Applicant: Doswell Projects Limited
Site: Land West of Yapton Lane, Walberton
Proposal: Non-Material Amendment pursuant to Section 96A of the Town and Country Planning Act 1990 (as amended) to amend the approved plans as submitted under the Reserved Matters application WA/52/24/RES by omitting garages, amendment to the GIA of 22 dwellings, replacing estate railings with post and rail fencing, the relocation of the pumping station and the inclusion of ASHP and PV Panels.

This covering letter accompanies a Non-Material Amendment (NMA) application in respect of Land West of Yapton Lane, Walberton, seeking to amend the approved plans under planning permission ref. **WA/52/24/RES**. The proposed amendments comprise the omission of the approved garages, amendment to the GIA of 22 dwellings, the replacement of estate railings with post and rail fencing, the relocation of the pumping station and the inclusion of ASHP and PV Panels.

DRAWING TITLE  
**Plot 42**

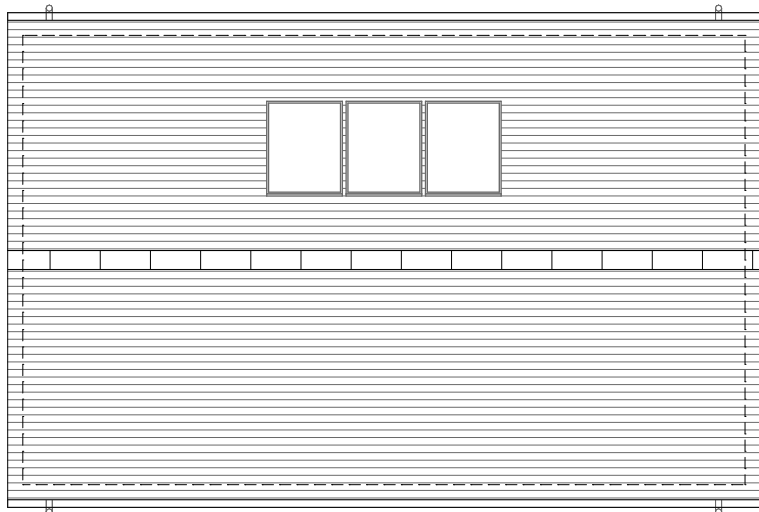
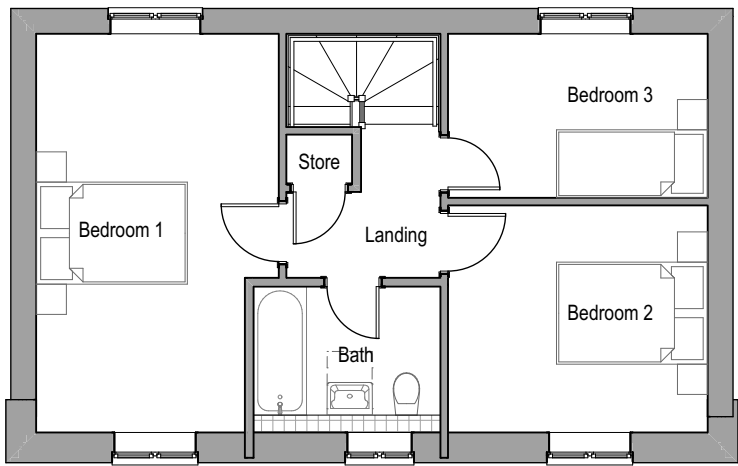
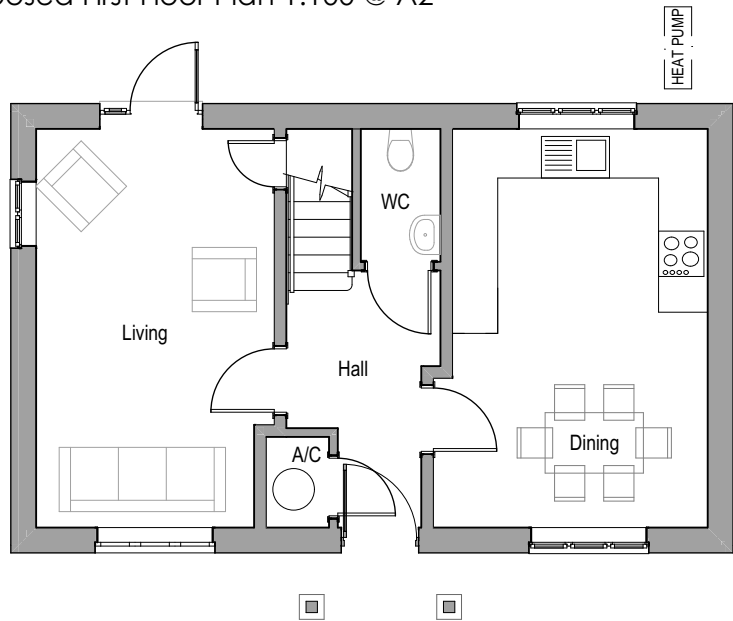
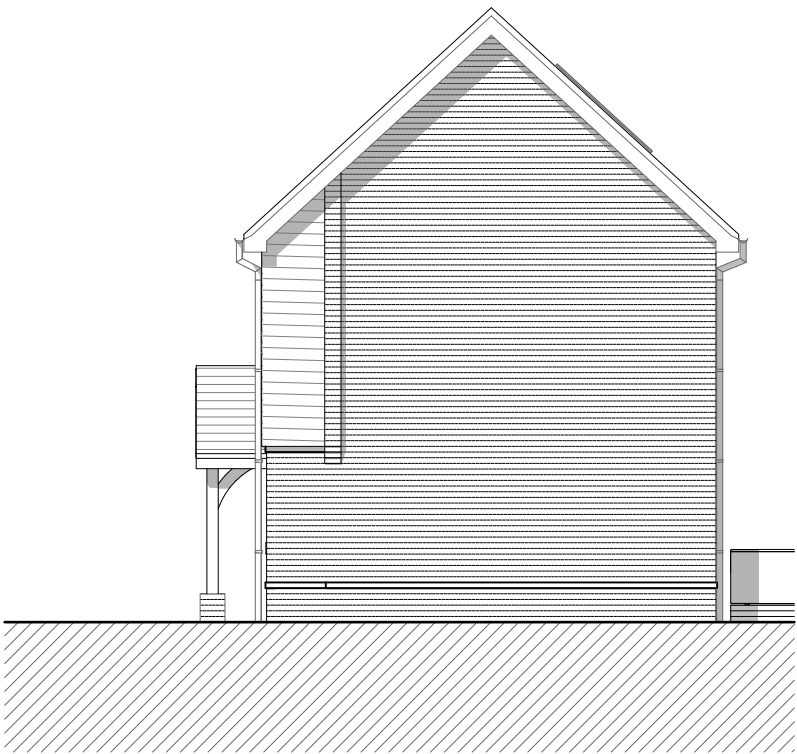
It is proposed that the garages serving Plots 9, 29, 30, 48, 43, 42, 41, 39, 38, 37, 36, 35, 34, 33, 32 and 31 are omitted as part of this NMA application.

The plots proposed to be reduced in size are Plots 5, 6, 10, 11, 19, 24, 27, 28, 29, 30, 31, 34, 35, 36, 37, 38, 39, 40, 41, 42, 43 and 48. Further details of the proposed changes are provided within the corresponding plans and supporting documents submitted as part of this application.

Because of the reductions in GIA, amendments to the roof forms of Plots 10, 11, 22, 23, 25, 26, 31, 42, 46 and 47 are also proposed. Further details of these changes are illustrated on the corresponding plans, elevation drawings and site plan.

There have also been amendments to the rear fenestration, with the existing double patio doors replaced by a French-style patio door comprising a single hinged door with narrow fixed sidelights.
